Preliminary review - additional review required
 Reviewed by: malcuran
 07/10/2024 12:12:32 PM

10090 OTERO AVENUE
 Legal: LOT M, VAC W 20.0 FT OF OTERO AVE, BLK B SPRING CREST FIL 2
 Area: 115,869 sq ft 2.66 ACRES
 Schedule #: 5124004009
 Zoning: RR-2 (equivalent RR 2.5)
 Owner: MARY AND CHARLES DE LAY
 Mailing: 10090 OTERO AVE COLORADO SPRINGS CO, 80920-1537

SITE PLAN
 SCALE: 1" = 20'-0"

SITE PLAN

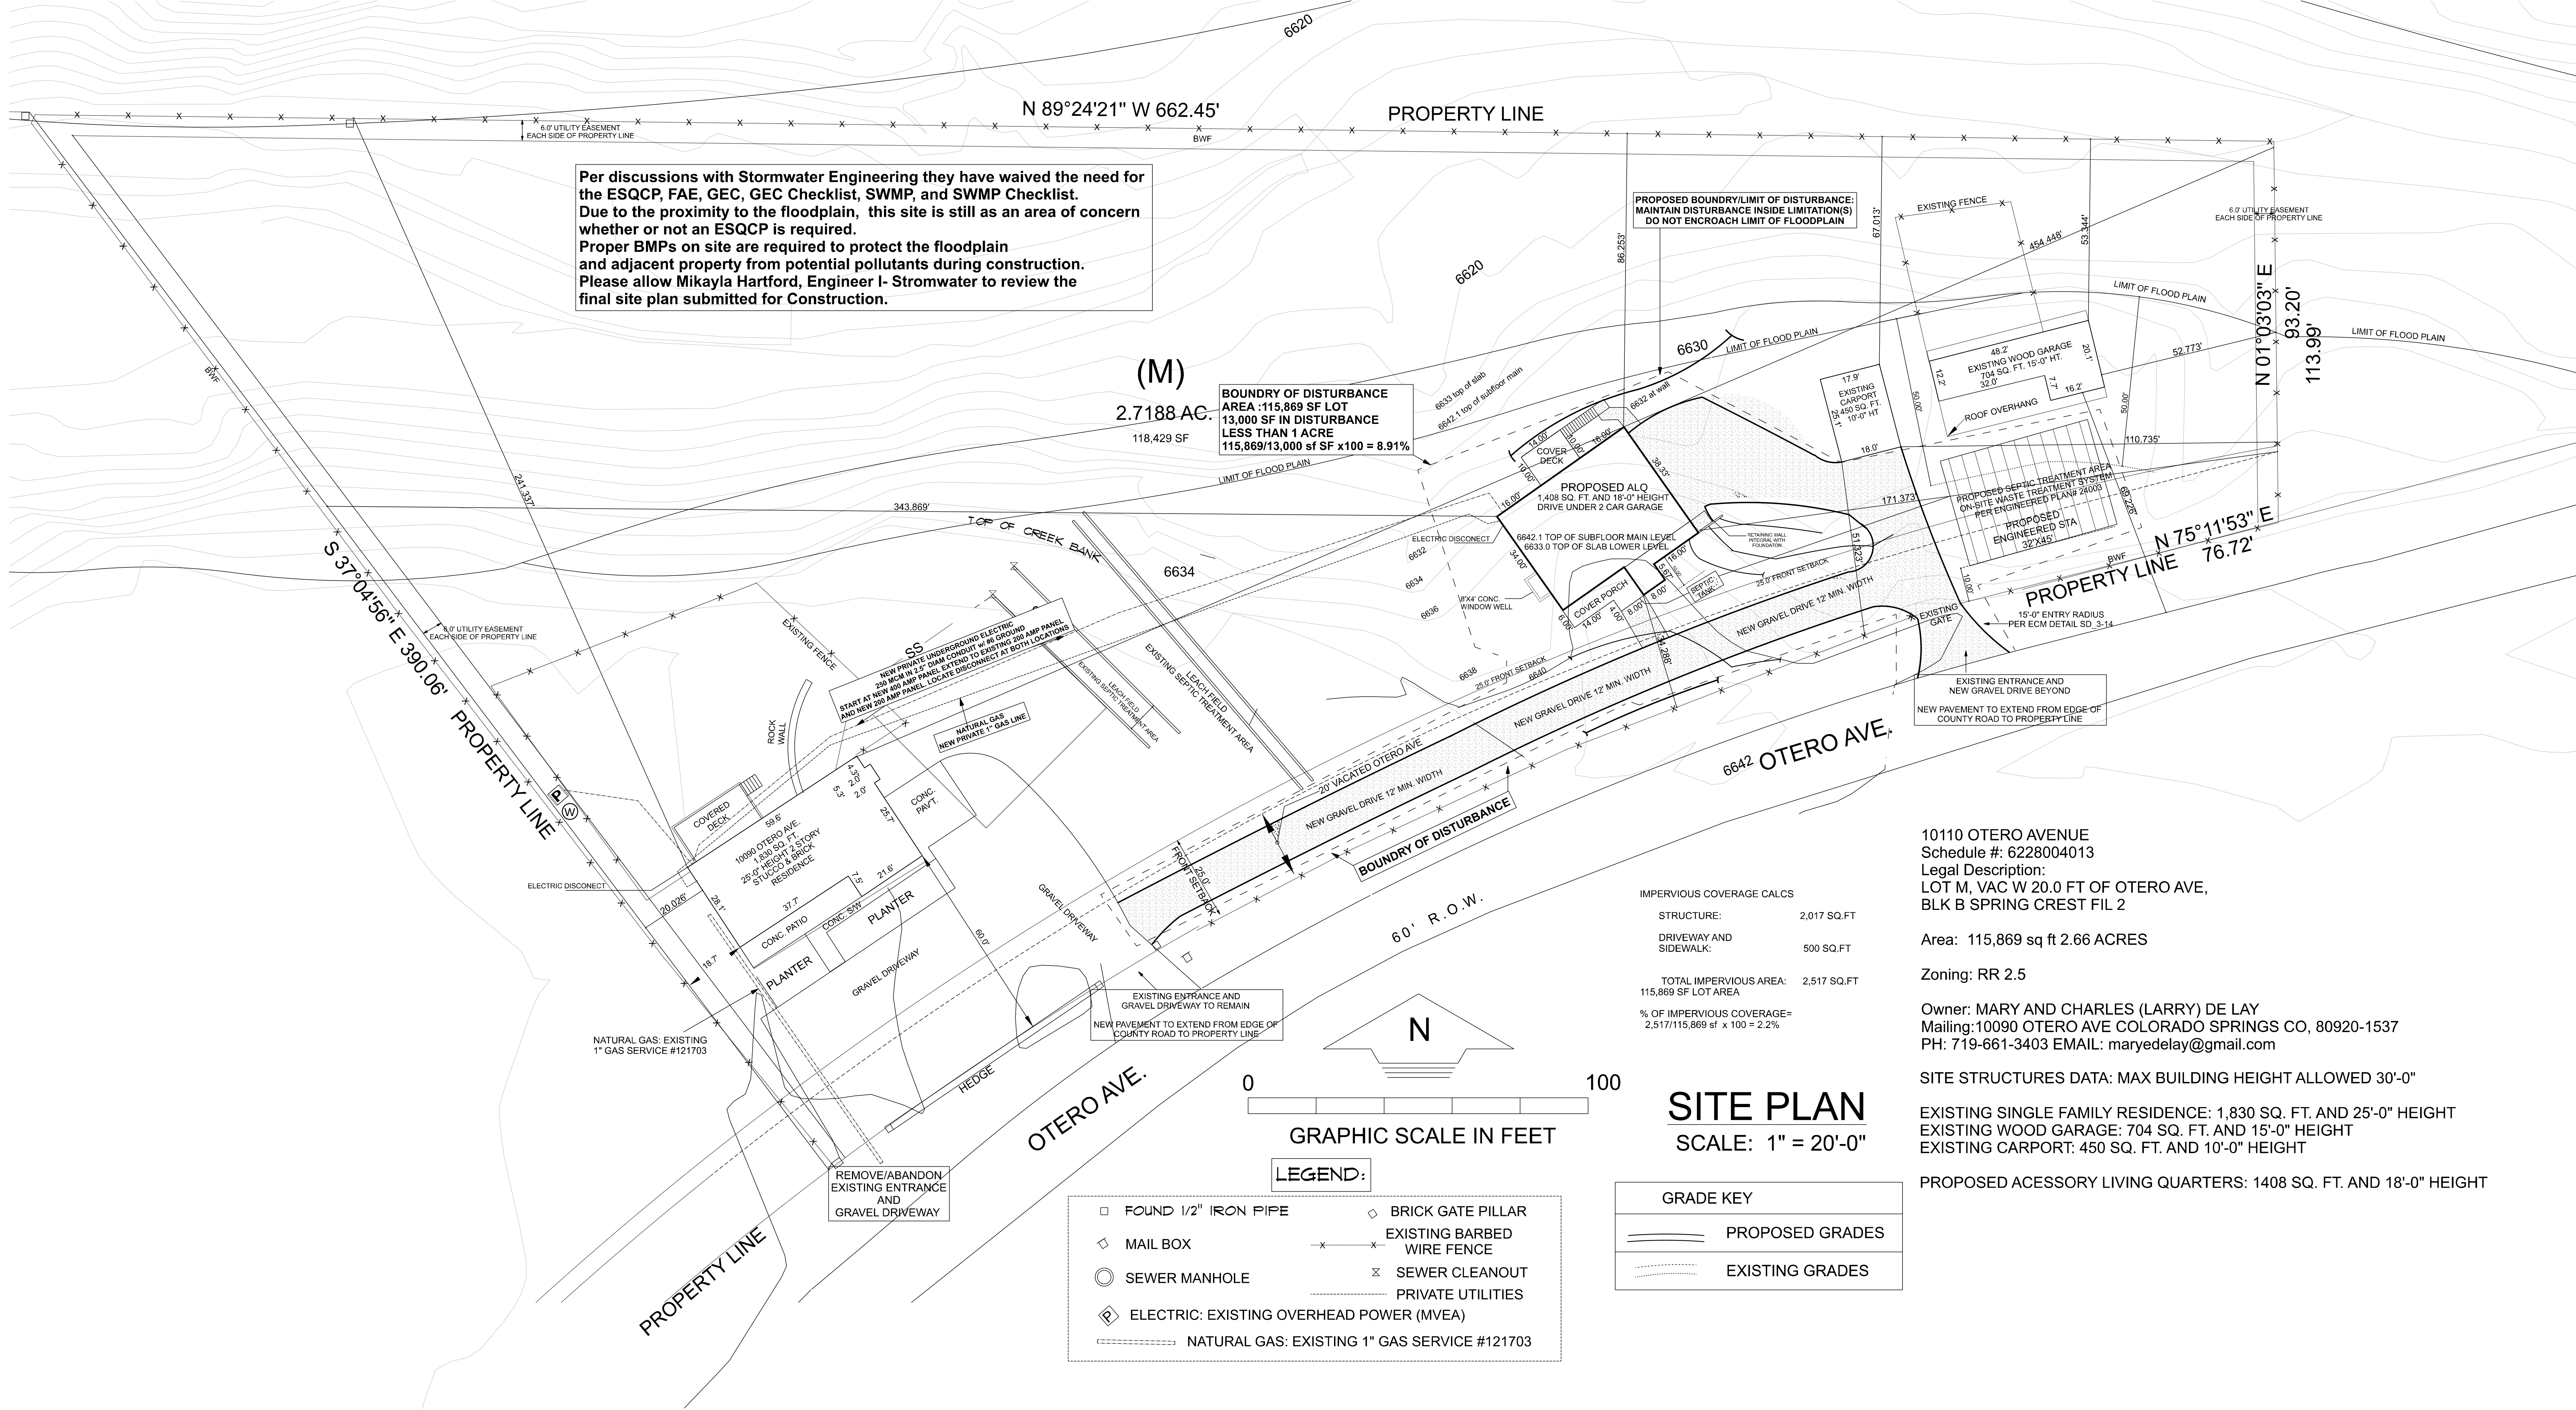
Show and label all existing proposed utility service lines with diameter, material, and either Public and/or private.

Show and label existing 1" gas service line CSU #121703
